Our Ref: R/2016/41/A
File No: 2020/180939
Your Ref: SSD-7874

Response to Submissions – Stage 1 Concept Proposal for the Harbourside Shopping Centre Redevelopment – SSD-7874

Figure 4.5.1 Waterfront setbacks proposed (FJMT - with key areas of increase and decrease annotated by Architectus)

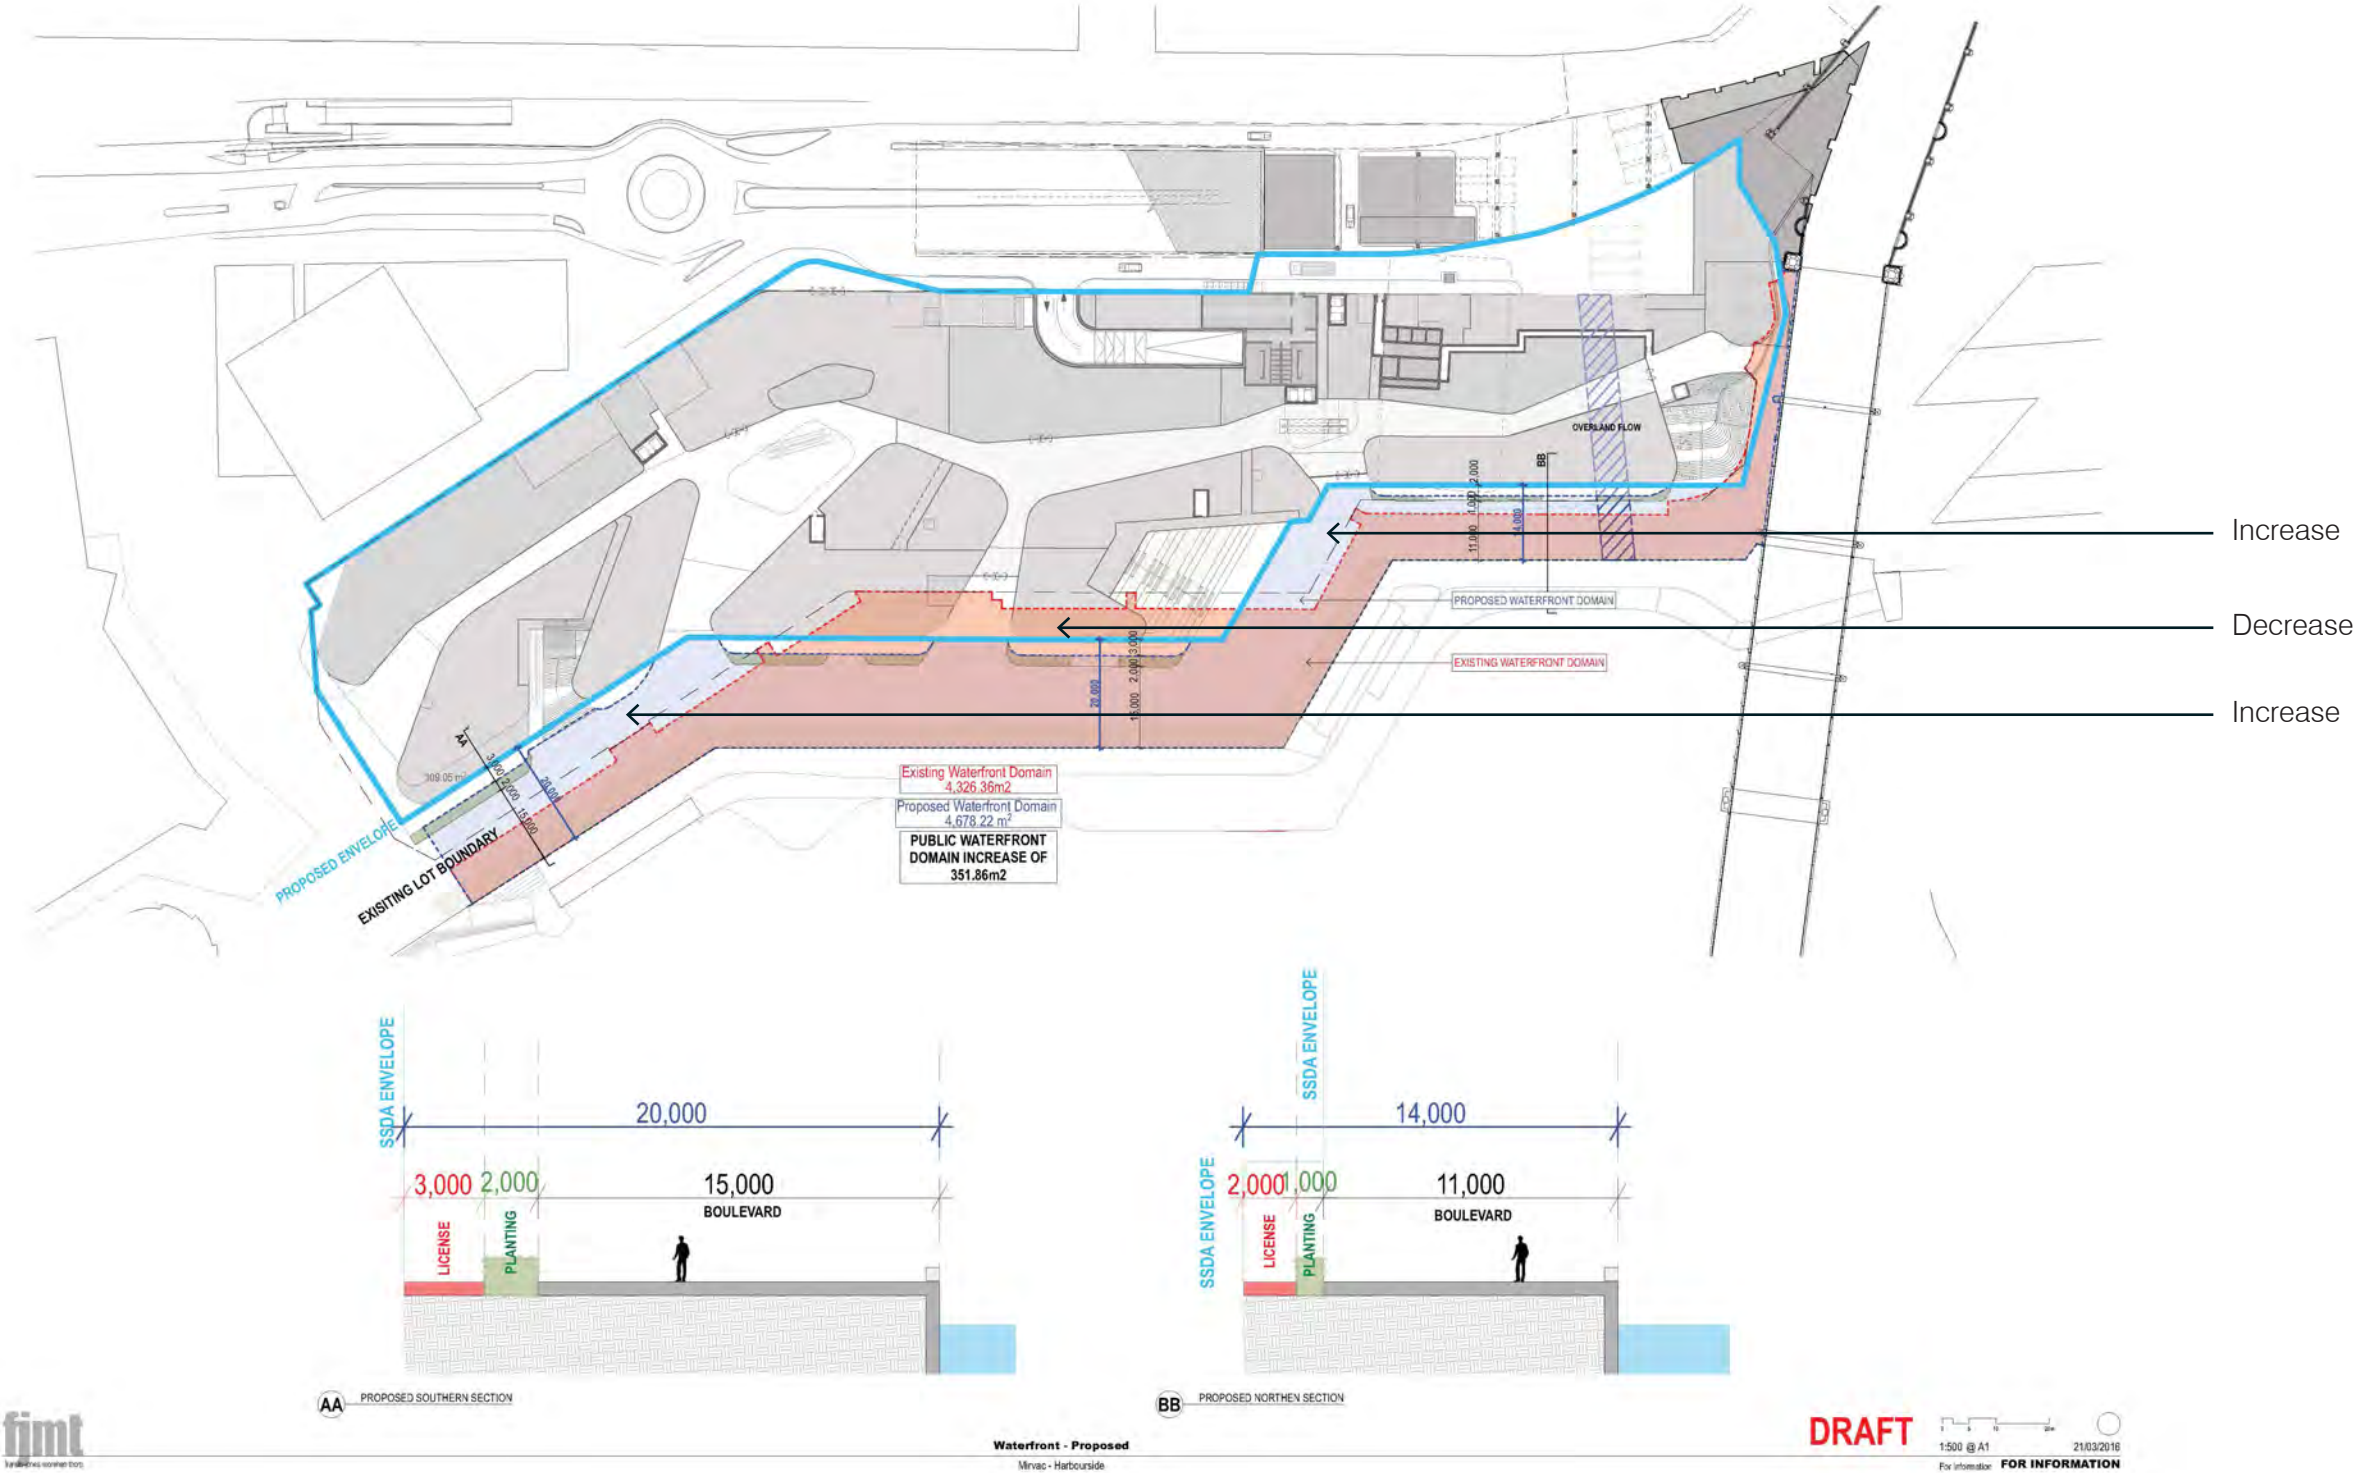
Whilst the proposal includes a consistent width of 20m along the foreshore, the 519sqm increase to the existing 4,470sqm is not a substantive increase to the foreshore promenade. The existing foreshore provides an area with a width of up to 25m which enables different spaces to be created to accommodate different programs.

Figure 4.5.5 Pymont Bridge setbacks proposed

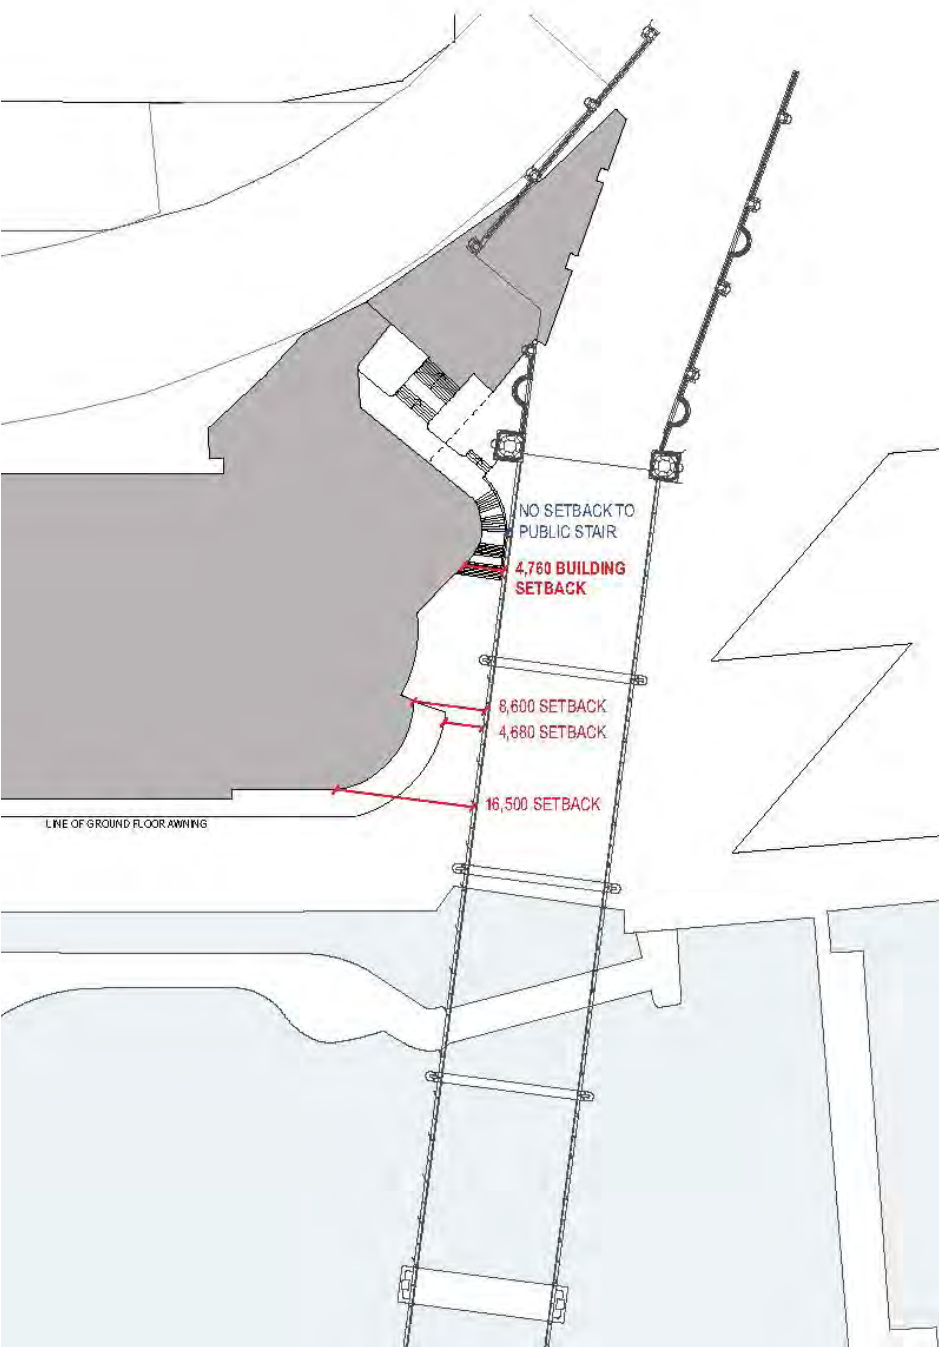
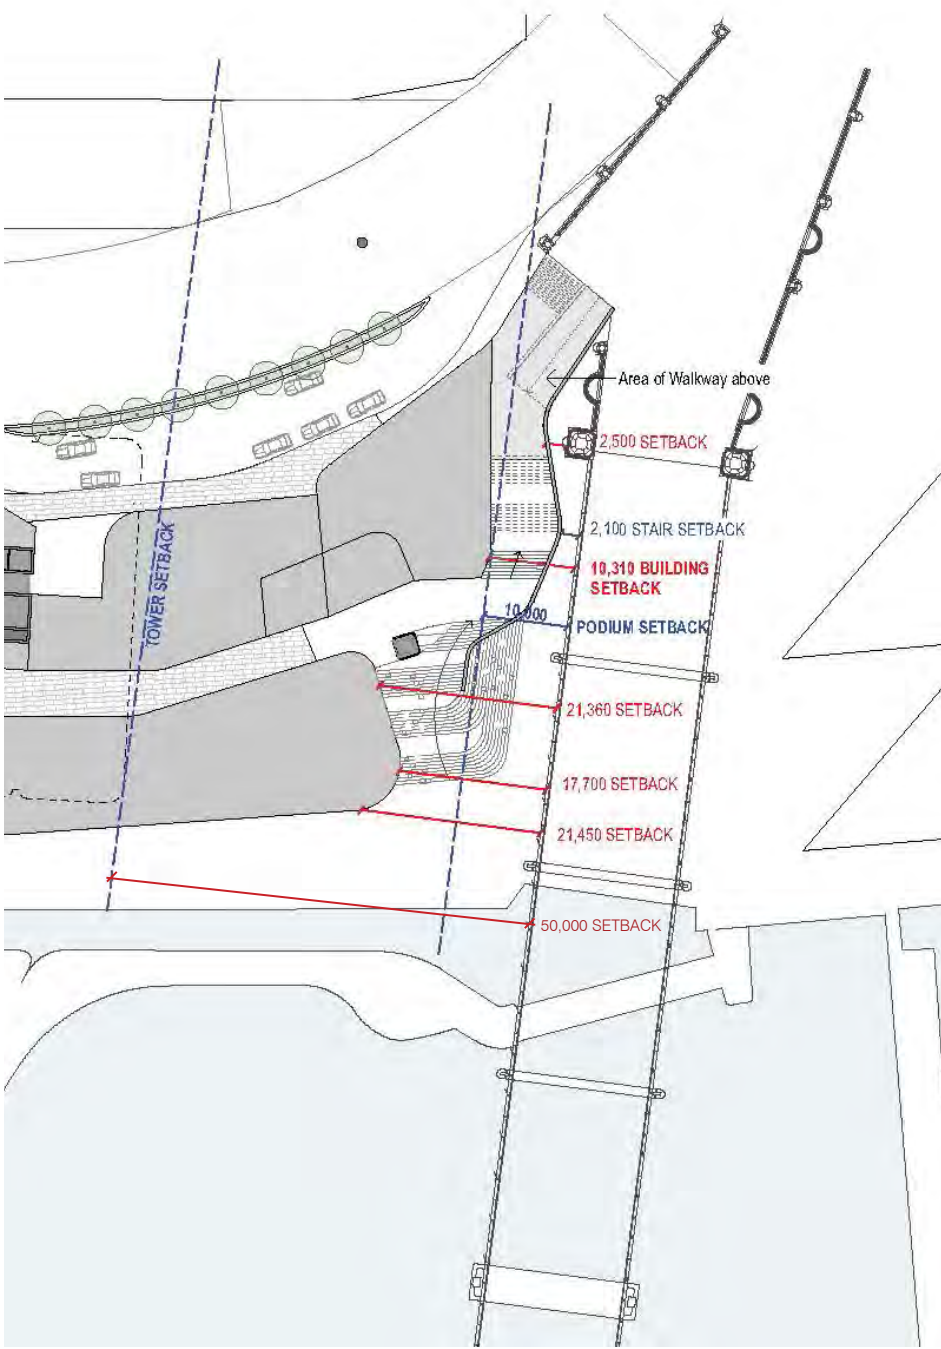
Notwithstanding the general improvement to the building envelope, the concern of the podium envelope remains from a heritage perspective. Whilst the amended design provides increased setbacks to the Bridge and a rationalised northern edge/sightline, the modifications to the podium and underbridge stairs are tokenistic and does nothing to ameliorate the unacceptable visual impact and curtilage to the Pyrmont Bridge.

It is noted that the previous Goods Line Workshop Shed located at the southern side of the Bridge was only slightly higher than the Bridge surface. The extant Harbourside Shopping Centre height of RL 17.4 largely reflects the former Shed's height. The visual prominence of the Bridge as viewed from the west are not significantly affected. The proposed podium has a height of RL 24, which is 7.5m taller than the extent structure and approximately 13-14m taller than the Bridge surface at RL 11.5. The significant increase of the new structure's height warrants a larger setback from the Bridge to reduce its imposing impact.

Following a 30 degree vertical visual angle, a RL25 structure needs to have a 25m setback from the southern edge of the Bridge. The portions of the northern end of the podium whose RL is lower than RL 25 may have a reduced setback less than 25m. A tiered form of the podium has the benefit to make the green roofs of the lowered podium visible from the Bridge. If a universal 25m setback is not made to the RL25 podium, the setbacks and a 30 degree slant sightline should be adopted as previously recommended.
